Rezoning Transportation Analysis

Petition Number: 2023-122

Revision Log:

Date	Description
10-25-23	First Review (NK)
11-22-23	Second Review (NK)
1-24-24	Third Review (NK)

**EMPIRE COMMUNITIES
REZONING PETITION NO. 2023-122
11/13/2023**

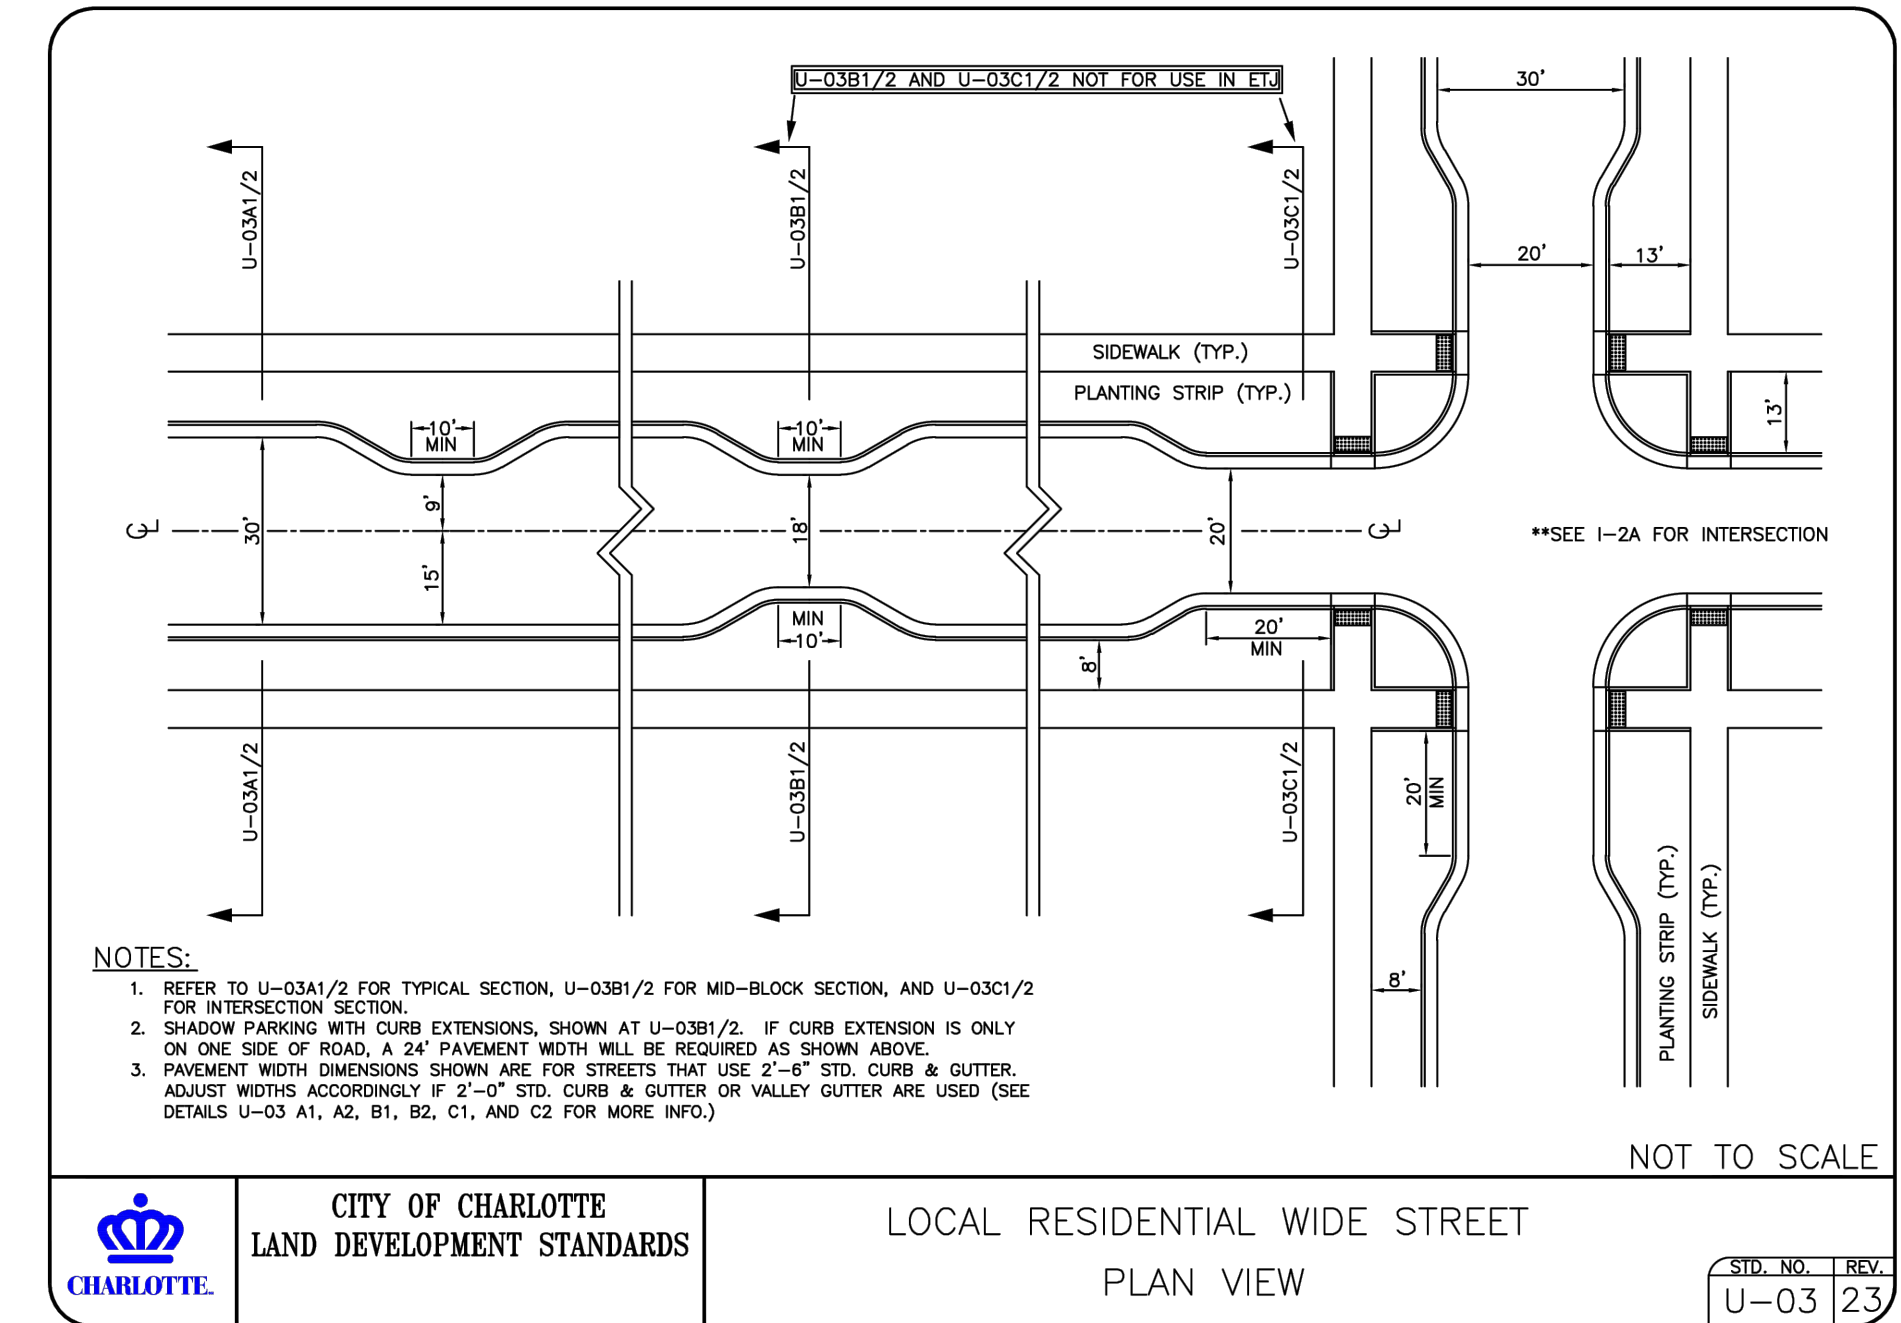
~~a. **Wright Avenue:** The future location of curb and gutter is in its existing location.~~

~~The required cross section is CLDSM U-03A1 Local Residential Wide Street w/ 8' Sidewalk.~~

~~Label and dimension the curb and gutter from the centerline for each road on the site plan.~~

~~3. **Revise site plan and conditional note(s) to commit to dedicate 35.5 feet of right-of-way from the road centerline of Wright Avenue. The site plan shall label and dimension the right-of-way from the road centerline.**~~

- ~~7. Revise site plan and commit to meeting Public Right of Way Accessibility Guidelines (PROWAG) requirements for on street parking. The required number of spaces can be found in table R211 in PROWAG and design requirements for on street parking can be found in article R310 of PROWAG.~~
- ~~8. Revise site plan to remove crosswalk striping at all unsignalized intersections.~~
- ~~9. Revise site plan to extend Wright Avenue to the property line.~~
- ~~10. **Outstanding Comment from 10-25-23** : Revise site plan to include a temporary turnaround for Street A.~~

~~**Clarifying Comment:** Since "Street A" is a dead end road, this will require a turn around. See CLDSM 11.18A for reference.~~

- ~~11. **New CDOT Request 11-27-23** : CDOT requests that the petitioner commit to upgrading the southern portion of pavement section along Jenkins Avenue east of the proposed development. An existing townhome development is committed to upgrading the northern portion of Jenkins Avenue.~~
